Application for a Non-Material Amendment Following a Grant of Planning Permission Town and Country Planning Act 1990 (as amended)

5 Hopton Hall Lane

Please describe the non-material amendment(s) you are seeking to make

Client: LUMB		
Project: 5 HOPTON HALL LANE		
Drawing Title: GA PLANS - GROUND & FIRST FLOOR		
Stage: Planning	Status: S0	
Drawn By: JL	Date: April 21	Scale: As Noted
Job Number: 2005	Client Project Number: n/a	Sheet Size: A1
Revision: 2005-004		P03

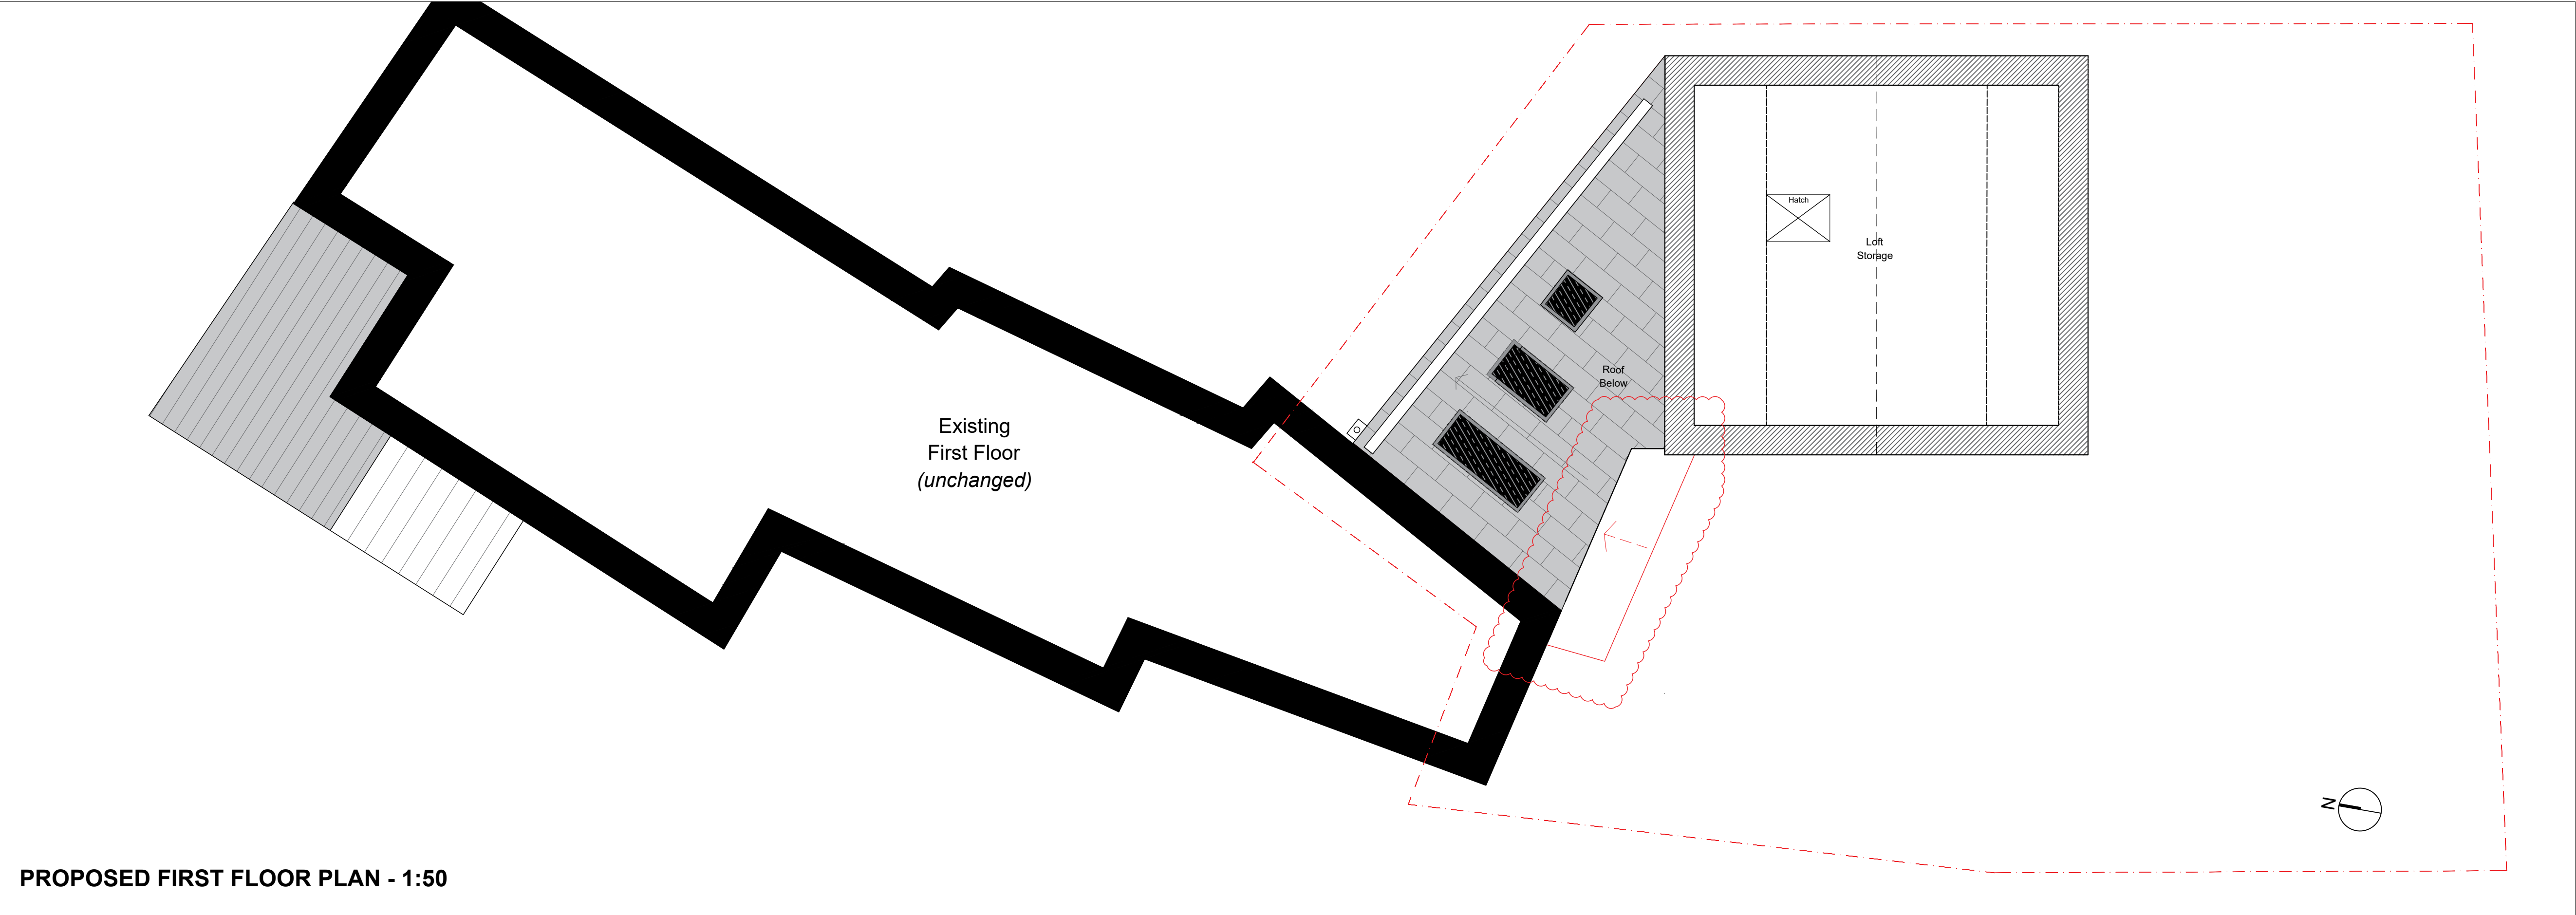
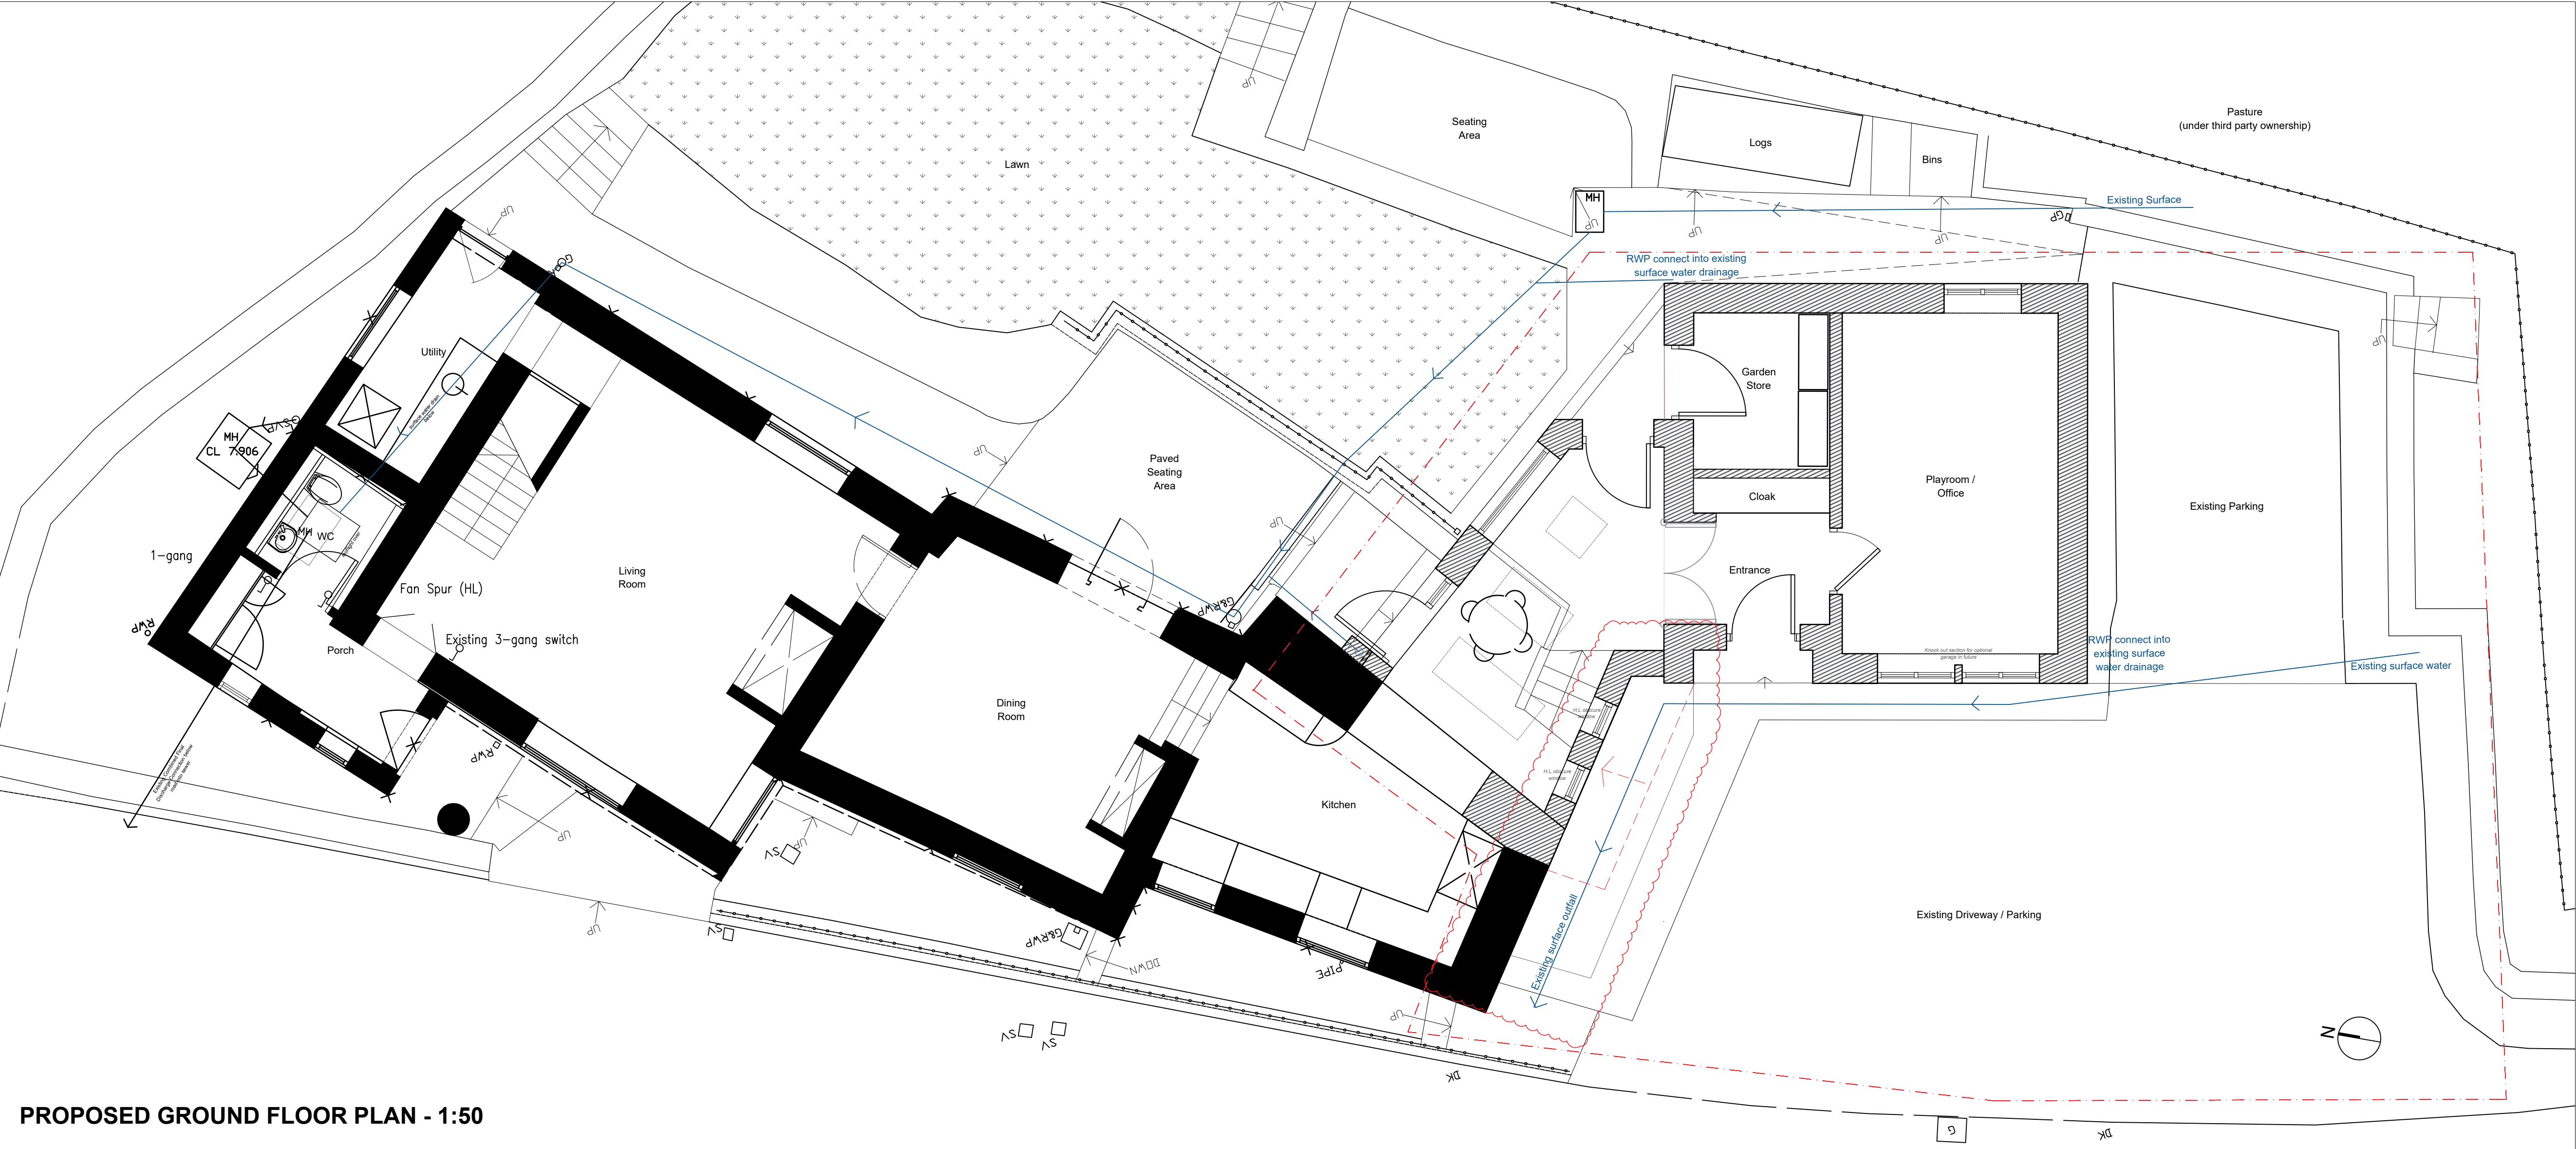
Item 1 - To avoid existing surface water drainage routes (as identified on the attached plan). The elevations remain as proposed, with a minor adjustment to a wall position.

Client: LUMB		
Project: 5 HOPTON HALL LANE		
Drawing Title: PROPOSED ELEVATIONS		
Stage: Planning	Status: S0	
Drawn By: JL	Date: April 21	Scale: As Noted
Job Number: 2005	Client Project Number: n/a	Sheet Size: A1
2005-006		Revision: P03

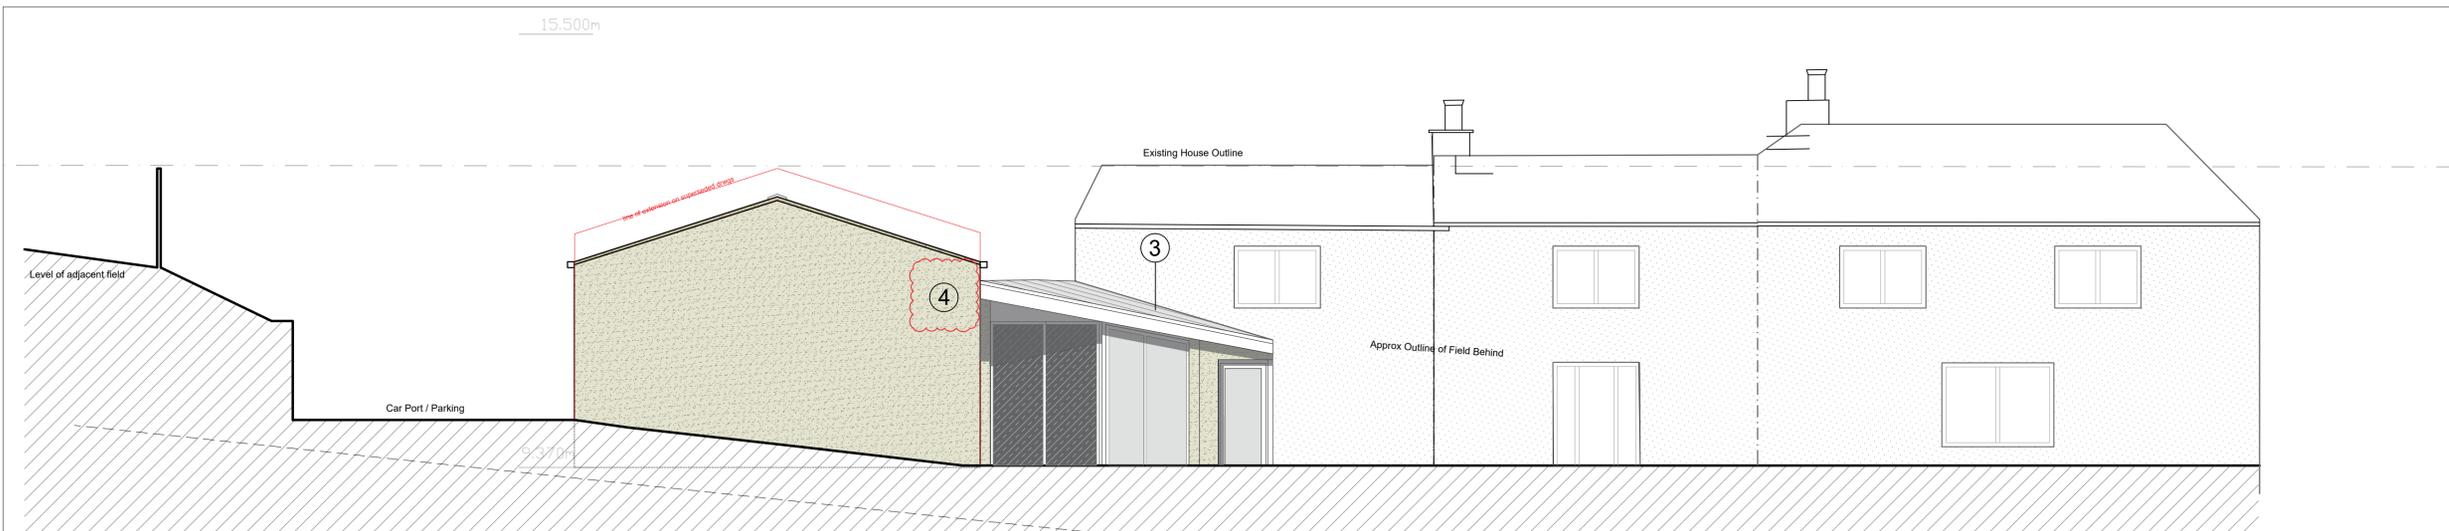
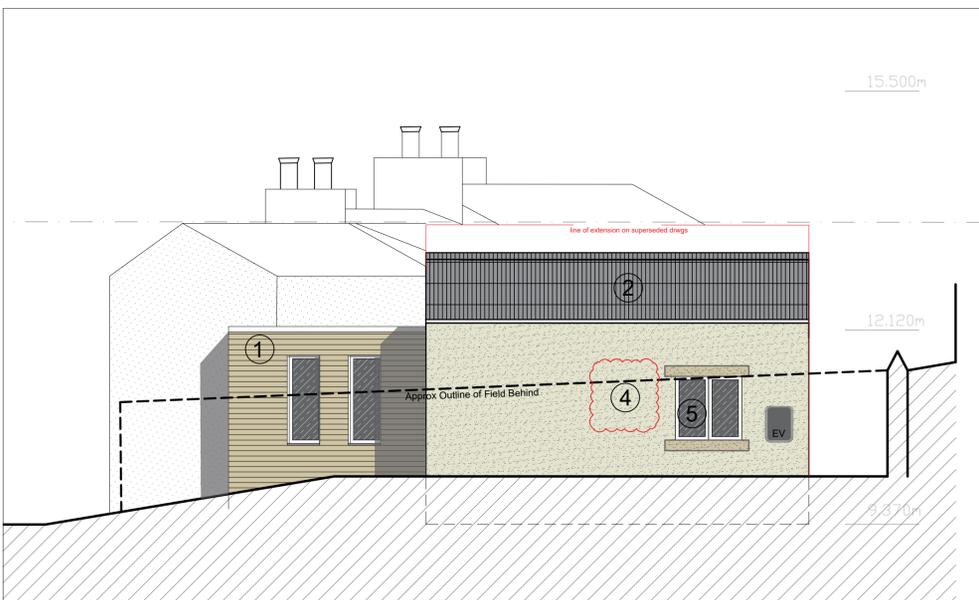
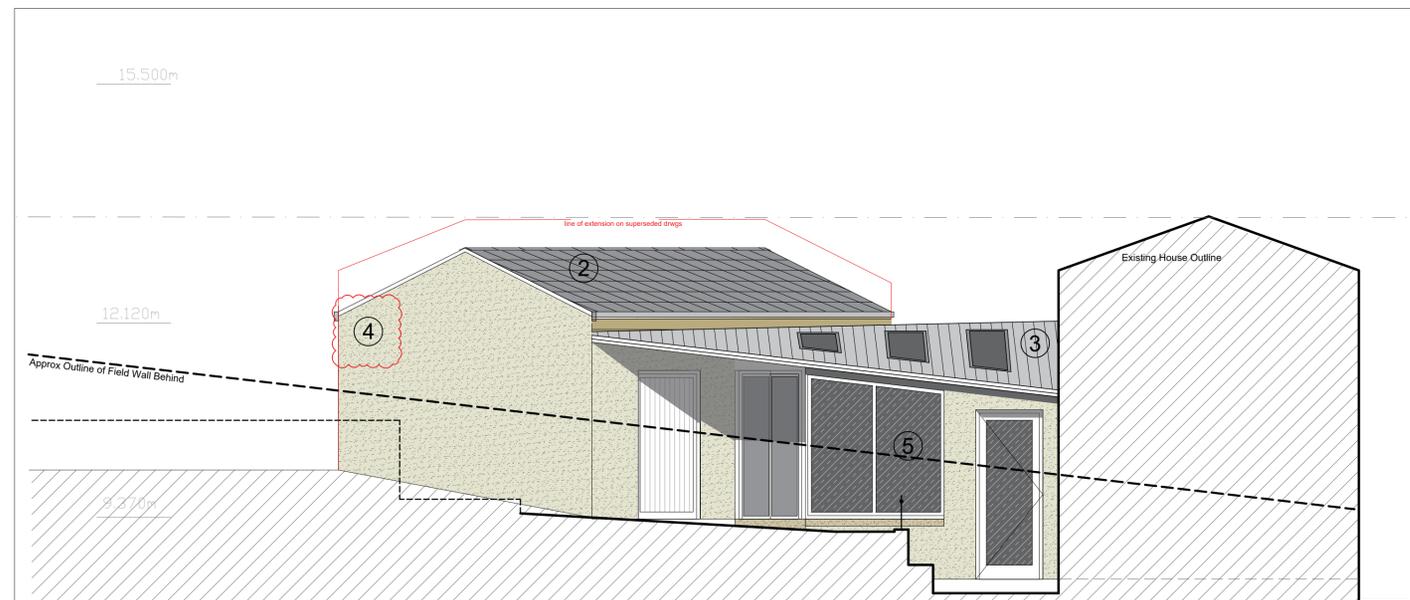
Item 2 - Upon further consideration we feel render will tie in more seamlessly with the existing dwelling house and avoid unnecessary costs on largely unseen elevations. (Locations identified on the appended drawings). There is also the potential to reuse 2no existing walls, which are already rendered.

Please also note that render is already identified on the materials board (Drawing reference - 202005_007_Materials Board) for other small areas of the development.
